15 December 2011

Reference No. 06623099-698-L-Rev1

**PASMINCO COCKLE CREEK SMELTER:  
PROPOSED DESIGN CHANGES FOR CONTAINMENT CELL CAP**

Figure 1: Concept of proposed geocomposite capping system

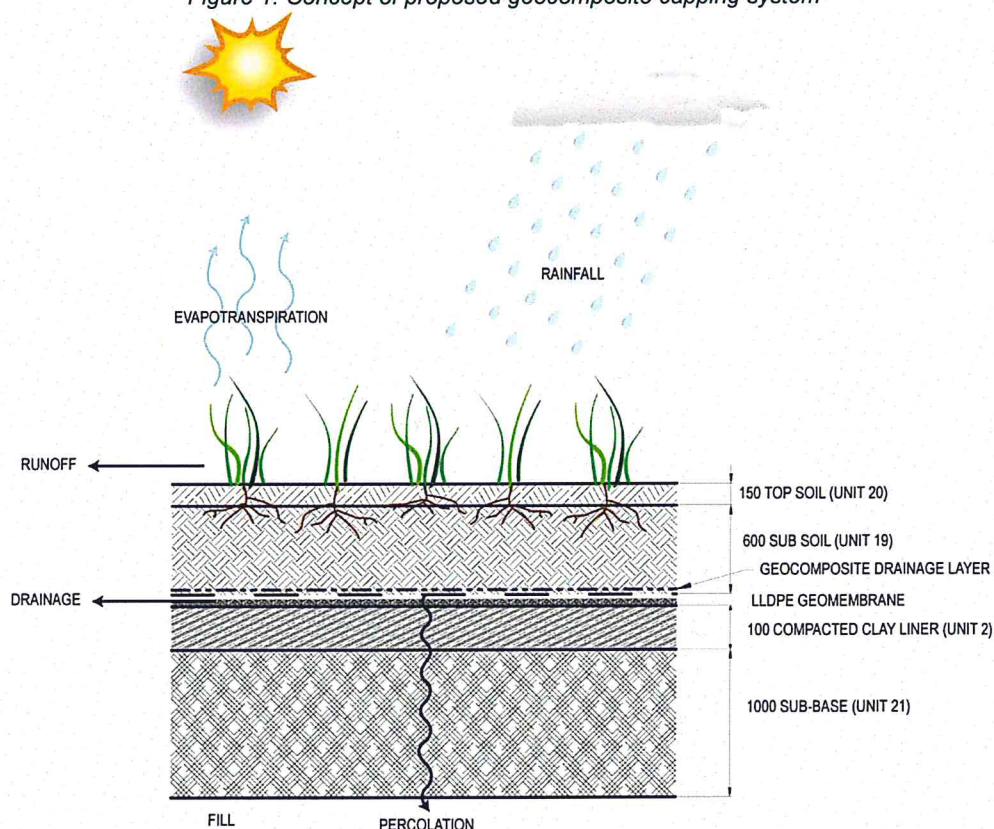
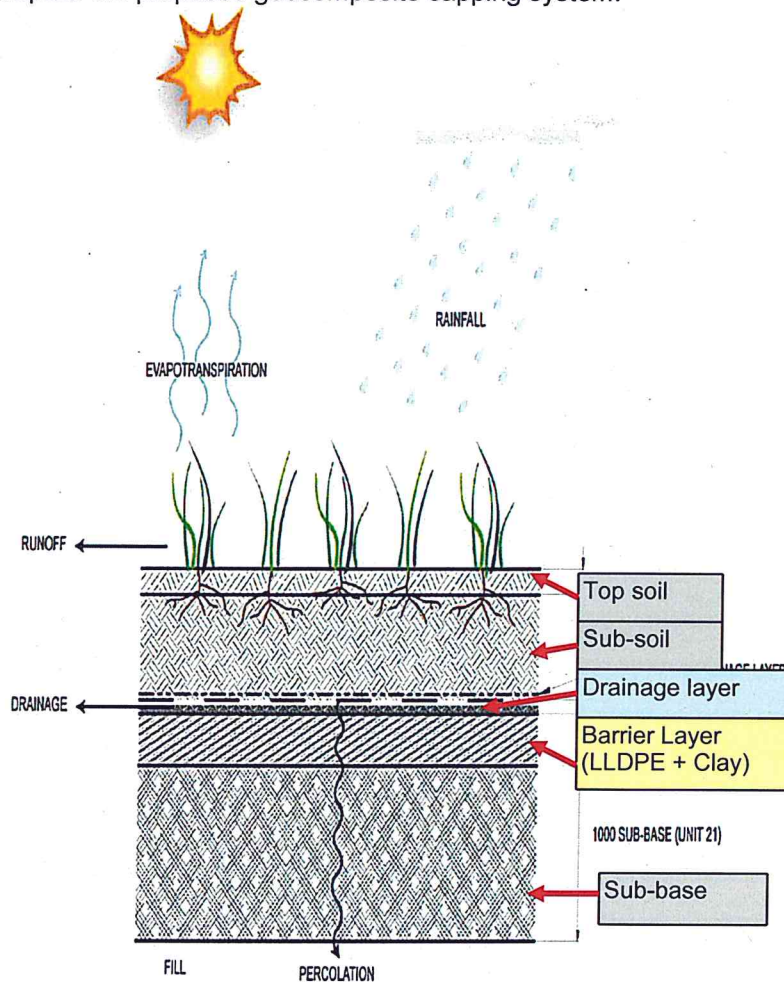
The current capping system design for Cell 1 and proposed design revisions are identified in Table 2 below and discussed subsequently. Revisions are proposed for the drainage layer and barrier layer components. The proposed design revisions apply primarily to the portions of the capping system on the top deck of Cell 1 that have not yet been constructed.

Component (listed from top to bottom)	Existing Design	Proposed Design
Topsoil Layer	150 mm thick; Topsoil specification (Unit 20)	No change proposed
Subsoil Layer	600 mm thick; Subsoil specification (Unit 19)	No change proposed
Drainage Layer	150mm thick; Subsoil gravel drainage layer specification (Unit 18); Overlain by filter geotextile (Unit 13)	Geocomposite drain (geonet drain core with geotextile filter bonded to both sides); thickness 5-10 mm.
	Subsoil drainage collection pipes (Unit 17) within subsoils drainage layer	No change proposed to pipe material; revised pipe layout and spacing
Barrier Layer	no geomembrane	LLDPE geomembrane (overlying clay liner); thickness 1 mm
	600 mm thick; Clay liner material (Unit 2)	100 mm thick; Clay liner material (Unit 2)

Component (listed from top to bottom)	Existing Design	Proposed Design
Sub Base	1000 mm thick: Sub base material (*select Unit 21)	No change proposed
Total System Thickness	2500 mm	1860 mm

The following figure shows the revised design proposed for the capping system for the top deck of Cell 1.

The proposed design revision replaces a relatively thick layer of Unit 2 Clay with a thin layer of Unit 2 Clay overlain by a geomembrane. In the proposed design the thin layer of Unit 2 clay provides a bedding layer for the geomembrane that serves two functions as follows: (i) clay layer will protect the geomembrane because it will not contain any gravel or rock particles that could puncture or penetrate the geomembrane; and (ii) clay layer in contact with the geomembrane provides a composite liner effect whereby the rate of water leakage through any defects in the geomembrane is likely to be significantly less than if the geomembrane was placed on more permeable soil. Because the development of a full composite liner effect (i.e., an order of magnitude or more reduction in leakage rate) is typically documented for clay layers that are substantially thicker than 100 mm, we consider that only a partial composite effect will likely be achieved with the proposed design. However, even a partial composite effect would result in leakage rates several times lower than for a single clay liner or single geomembrane. On this basis alone, it can be demonstrated that environmental impacts caused by infiltration through the proposed cap are likely reduced from the cap design which is currently approved, assuming that the cap is maintained suitably as per the maintenance requirements.

The proposed design revision for the top deck of Cell 1 includes replacement of a 150 mm thick gravel drainage layer with a 5 to 10 mm thick geocomposite drain (i.e., a geonet drain core with geotextile filter bonded to both sides). Geocomposite drains are often used in conjunction with geomembranes in geosynthetic capping systems. Advantages and disadvantages of geocomposite drains are discussed in the table below.
